19 March 2015

### Response to Submissions for SSD 6848 - Stage 3B of Lismore Base Hospital

Further to your letter of 18 March 2015, Health Infrastructure (HI) has reviewed the submissions received resultant from the exhibition of the above application. Submissions were received from the following parties/agencies:

Figure 4 – Truck Turning Paths

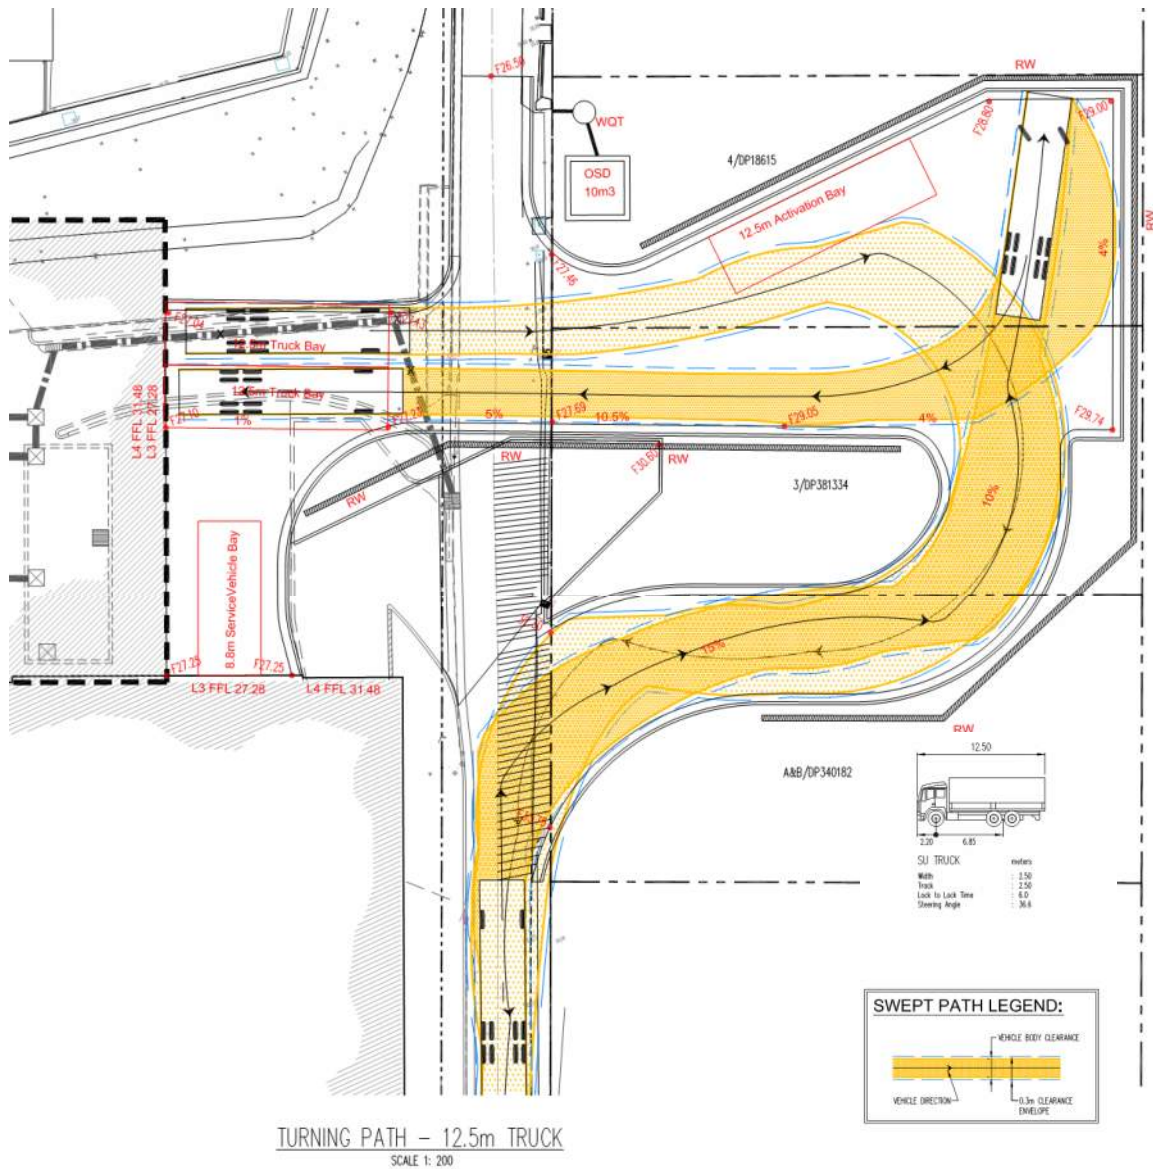
RMS	<p>"All service vehicles should be required to enter and leave the servicing area in Little Uralba Street in a forward manner. Reversing along or across a public road is not supported It may be appropriate to consider implementation of a Traffic Management Plan to manage this activity."</p>	The current design allows all vehicular movements onto Uralba Street to be carried out in a forward direction".
RMS	<p>"In accordance with the Delegation to Councils for the Regulation of Traffic the installation of any regulatory devices on local roads or within road related areas, including marked pedestrian crossings and parking signs, require the endorsement of the Local Traffic Committee (LTC) prior to Council approval."</p>	Noted.
TFNSW	<p>"Although recognised in the Traffic and Parking Review for Stage 3A, the SEARs requirement for a Travel Plan was not provided in the Stage 3B supporting documentation. TfNSW suggests the proposed Stage 3B provide a Sustainable Travel Plan and Transport Access Guide, endorsed by the</p>	A Sustainable Travel Plan and Transport Access Strategy will be developed in consultation with LCC and other relevant authorities. The Plan will include the review, assessment and analysis of the site in terms of accessibility with regards to public transport, bicycle and pedestrians. This will be complete prior to final occupation of the
